Response to Planning Application

From: Arun District Council Leisure & Greenspace

Application ref: WA/127/21/OUT

Location: Land west of Tye Lane Walberton

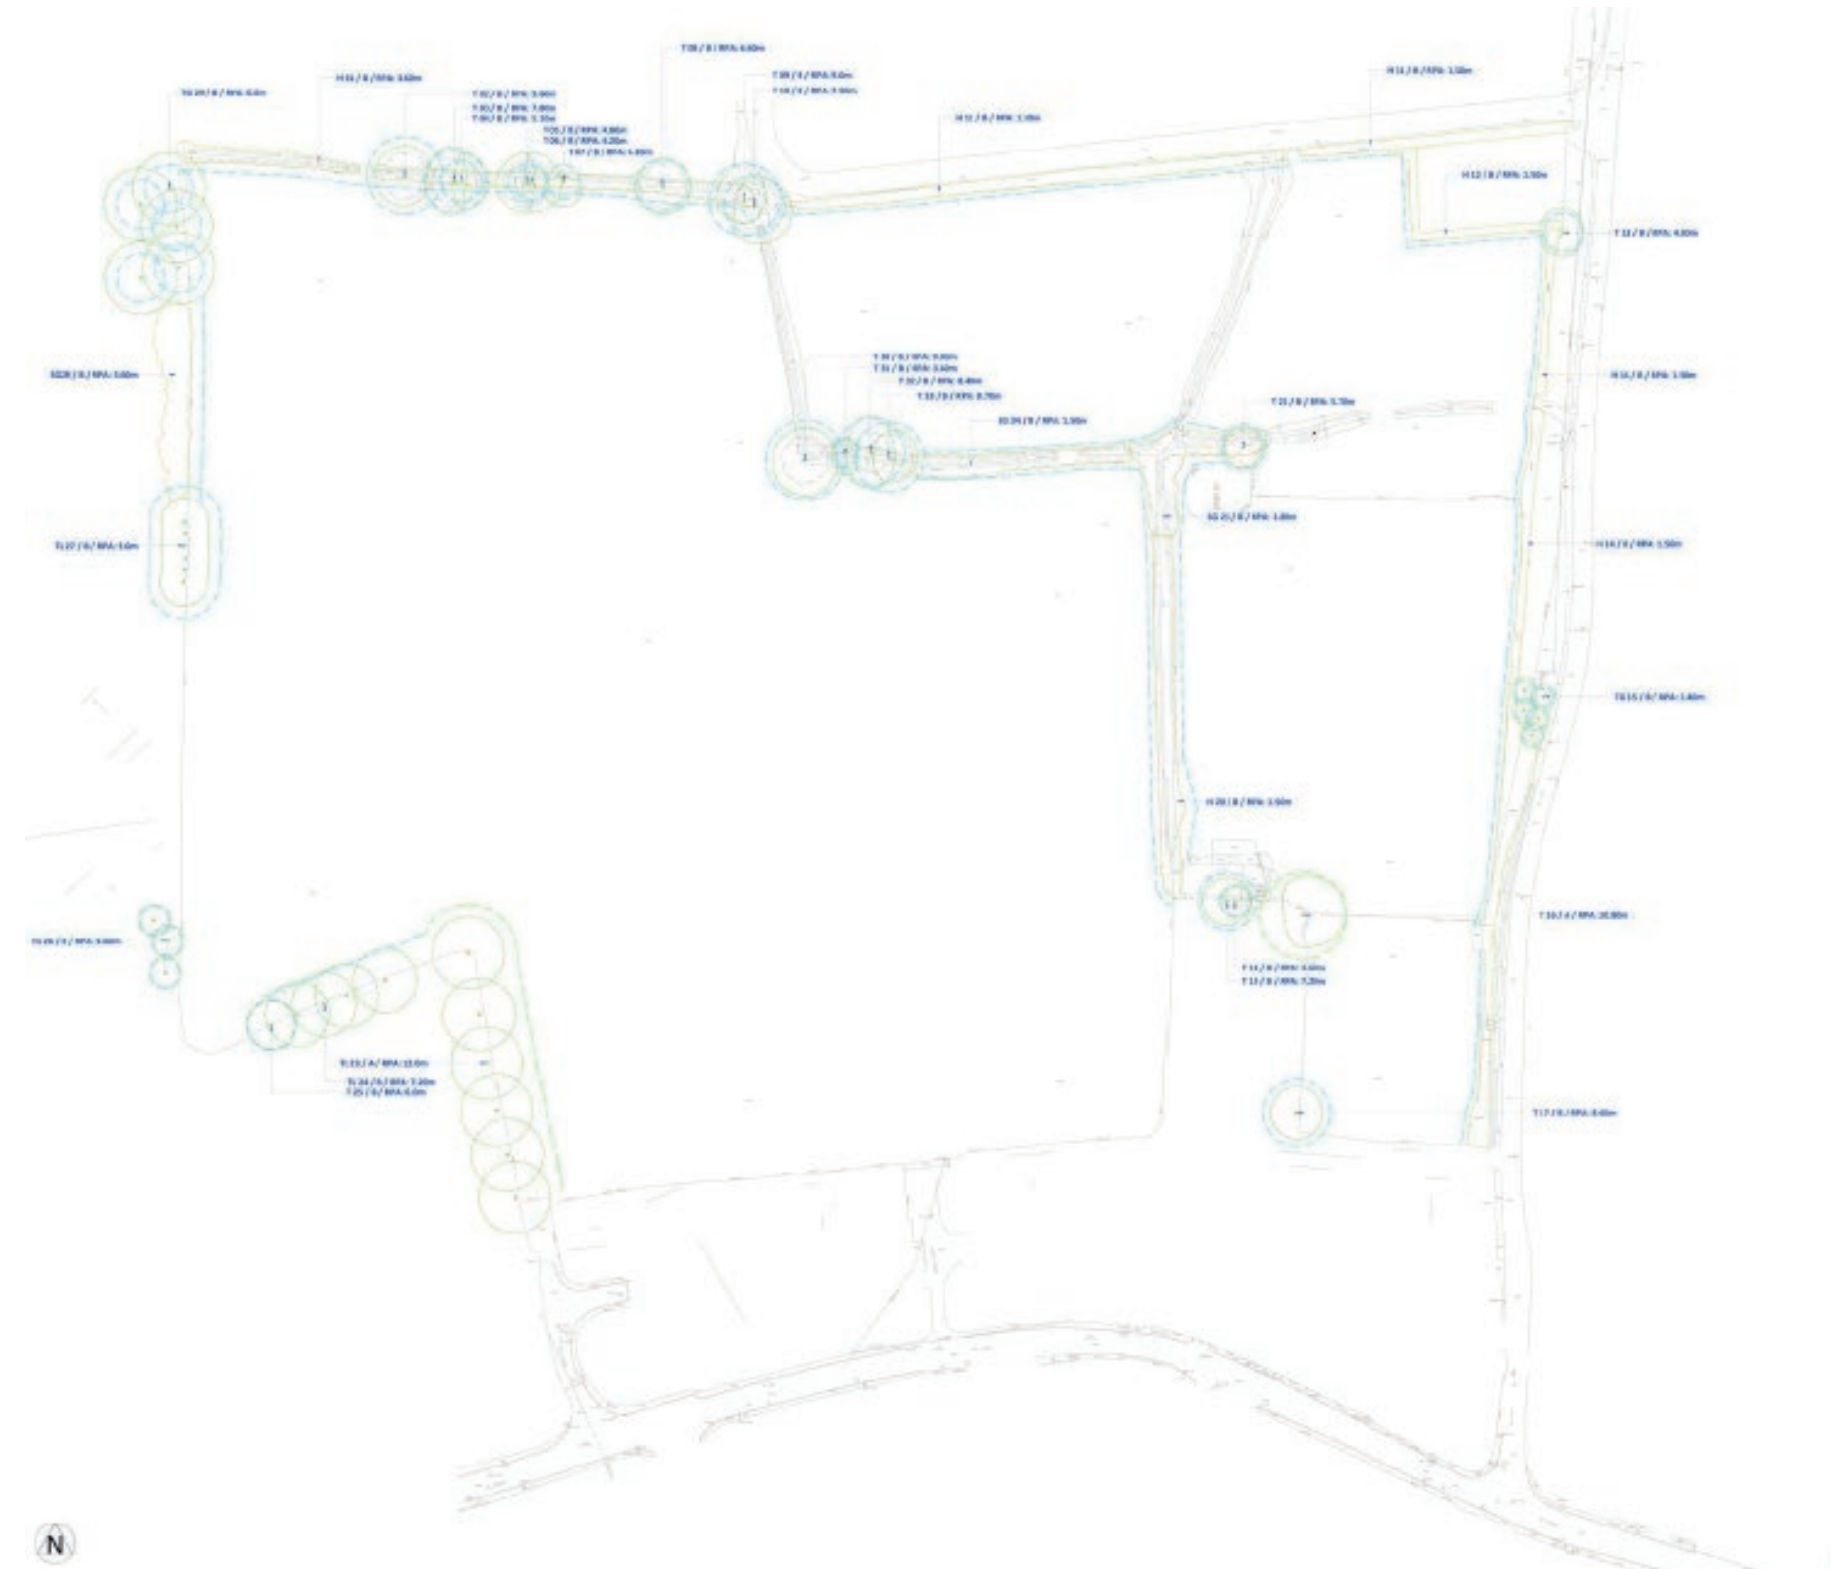
The information provided within Site layout Scheme 5 Plan 210824/CSL Rev A indicates a well-spaced site with good areas of POS both centrally and surrounding the areas of housing and a larger open area indicated to the south of the site. The indicative location of the areas of POS would appear to cater for the existing trees and hedges along the watercourse and those located within the site. Excluding the existing trees to the periphery of the site there would not appear to be a significant canopy cover in general with the exception of a few intermittent trees worthy of retention which must be protected and retained.
